From: Nicola Moore on behalf of Planning.Responses
Sent: 13 November 2019 09:53
To: Planning Scanning
Subject: FW: A/157/19/PL - Pedestrian Link - Quiet Waters to CALA homes site

A/157/19/PL - Pedestrian Link - Quiet Waters to CALA homes site

Project: LAND AT ROUNDSTONE LANE
Client: CALA South Home Counties Limited
Title: Footpath Link

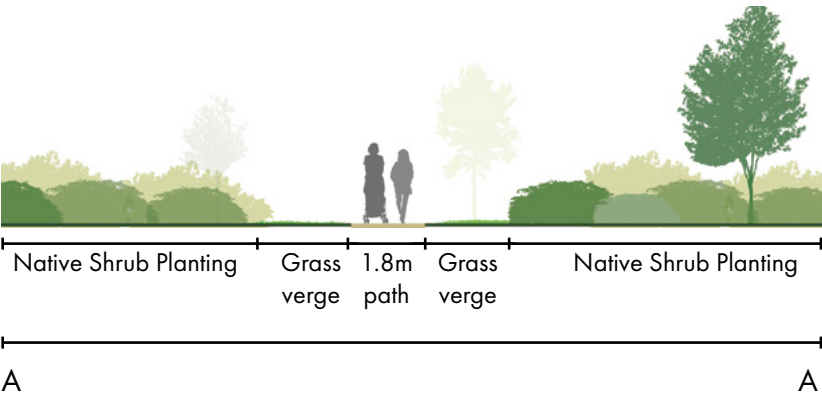
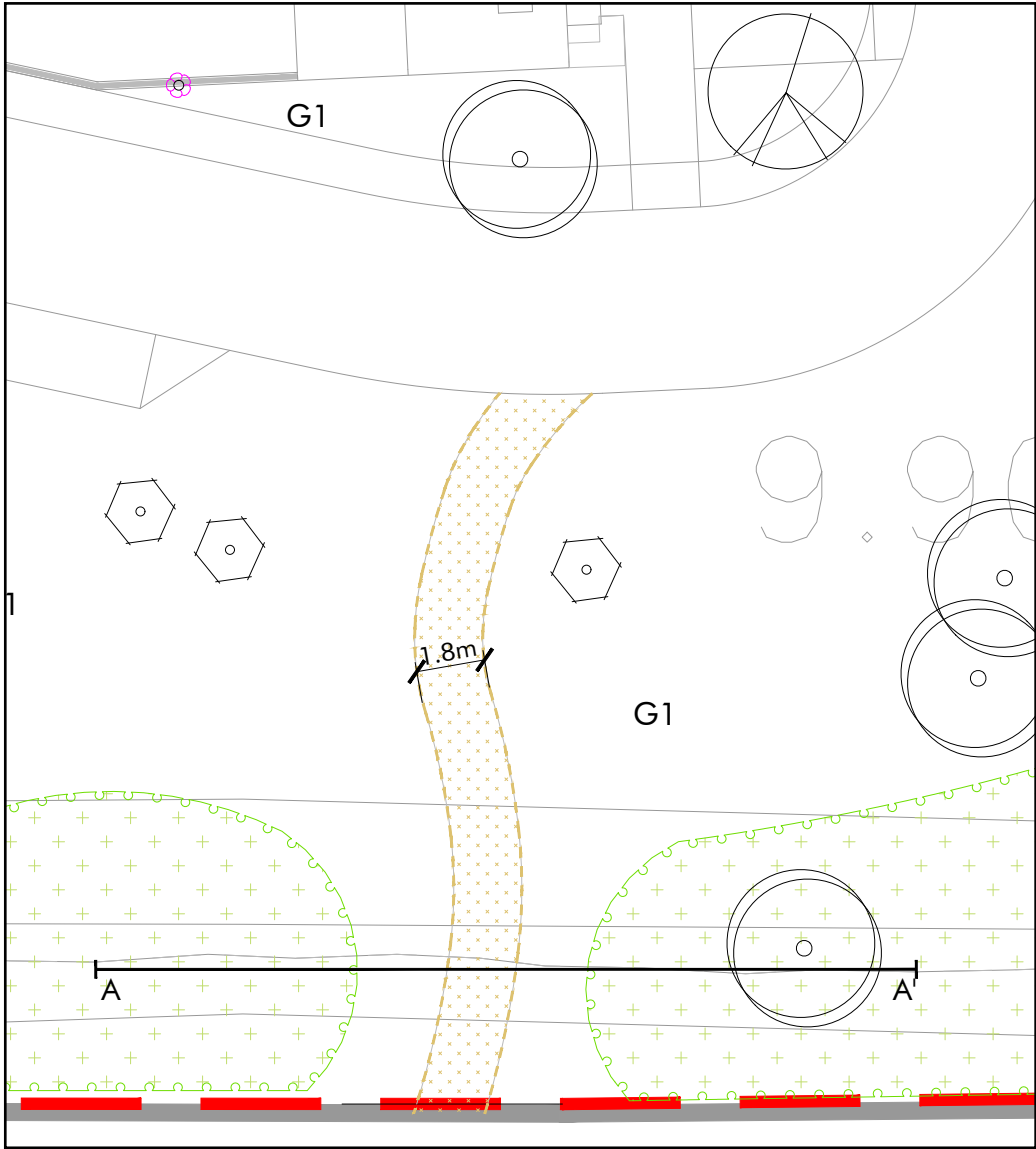
The plan shows the inclusion of a footpath to complete the footpath link between the Quiet Waters and CALA Homes developments. The principle of the footpath is accepted providing that the following have been taken in to account:

- The location and angle of approach of the footpath at the boundary is in accordance with the requirements of the Quiet Waters site. A plan needs to be provided showing the path on both sides of the boundary to confirm this.
- The levels of the path to be such that they aid the construction of the ramp on the Quiet Waters development and help minimise the difference in level between the two sites.
- The material of the path needs to match the proposed surfacing material of the link path on the Quiet Waters development. I did not observe other uses of the self-binding gravel on the CALA Homes site with footpaths nearby having a tarmac finish. The material should provide good accessibility and be low cost to maintain. Confirmation is required that the material is the same as proposed for the Quiet Waters site.
